City of Portland, Maine - Building or Use Permit Application
 389 Congress Street, 04101 Tel: (207) 874-8703, Fax: (207) 874-8716

Permit No: 09-1303	Issue Date:	CBL: 250 C005001
------------------------------	--------------------	----------------------------

Past Use: Single Family Home - Connected w/ permit# 091170	Proposed Use: Single Family Home - build a 540 sq ft detached garage	Permit Fee: \$110.00	Cost of Work: \$8,220.00	CEO District: 3
Proposed Project Description: build a 540 sq ft detached garage		FIRE DEPT: <input type="checkbox"/> Approved <input type="checkbox"/> Denied	INSPECTION: Use Group: Type	
		Signature:	Signature:	
PEDESTRIAN ACTIVITIES DISTRICT (P.A.D.)				
Action <input type="checkbox"/> Approved <input type="checkbox"/> Approved w/Condition <input type="checkbox"/> Denied				
		Signature:	Date:

37 Swan St

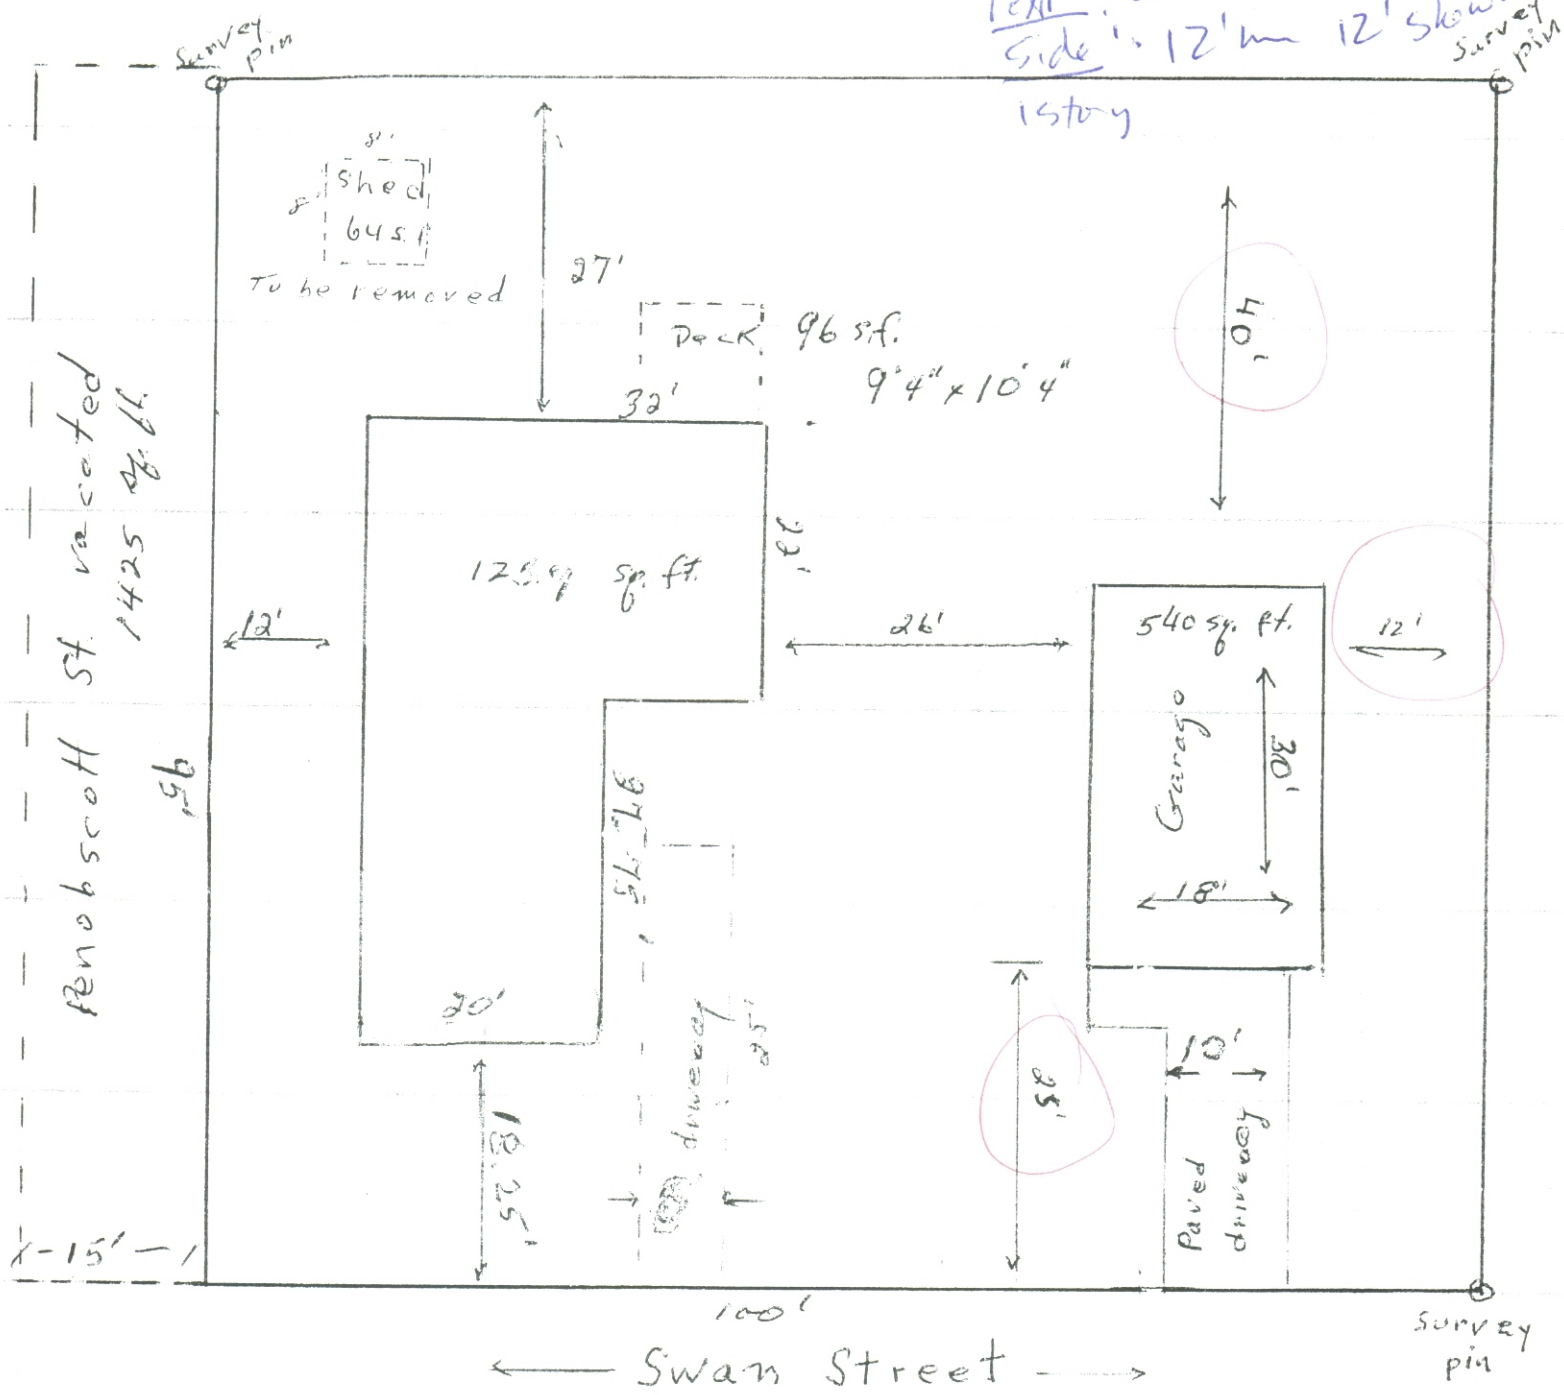
11/18/2009-mes: See the slab permit under #09-1170 - section 14-388 does not apply because this is not an enlargement of addition of an existing structure. It meets all the other R-1 dimensional requirements.

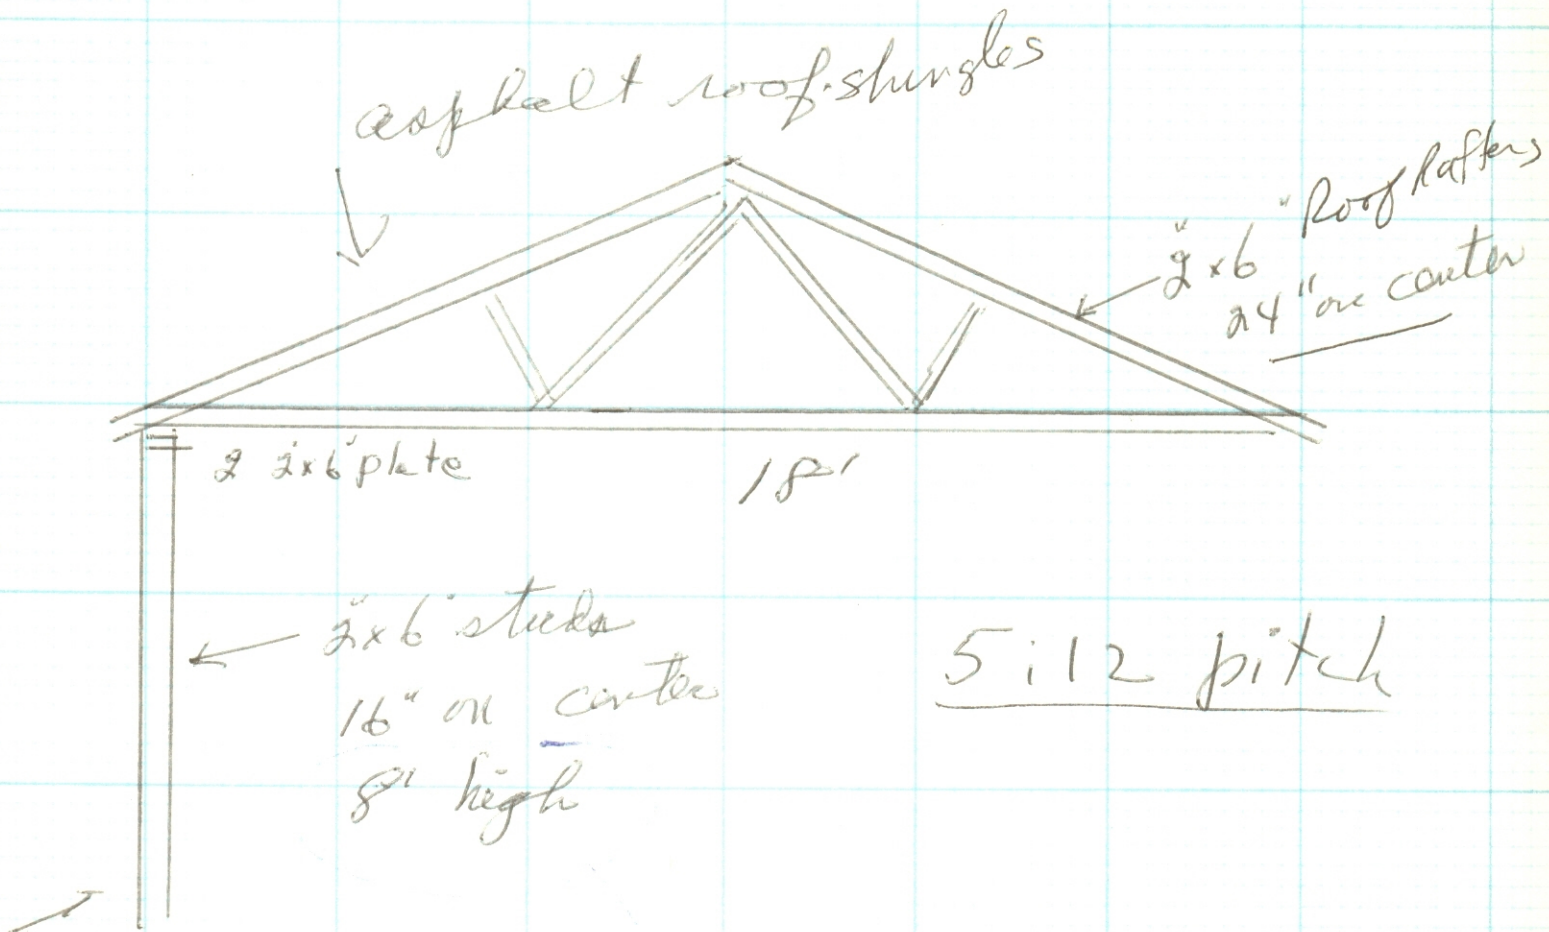
- 1) It is understood that this garage is only a single story and shall be no higher than 18' from grade to the midpoint of the roof (measured between the ridge and where the roof hits the outside wall).
- 2) Separate permits shall be required for future decks, sheds, pools, and/or garages.
- 3) This is NOT an approval for an additional dwelling unit. You SHALL NOT add any additional kitchen equipment including, but not limited to items such as stoves, microwaves, refrigerators, or kitchen sinks, etc. Without special approvals.
- 4) This property shall remain a single family dwelling. Any change of use shall require a separate permit application for review and approval.
- 5) This permit is being approved on the basis of plans submitted. Any deviations shall require a separate approval before starting that work.
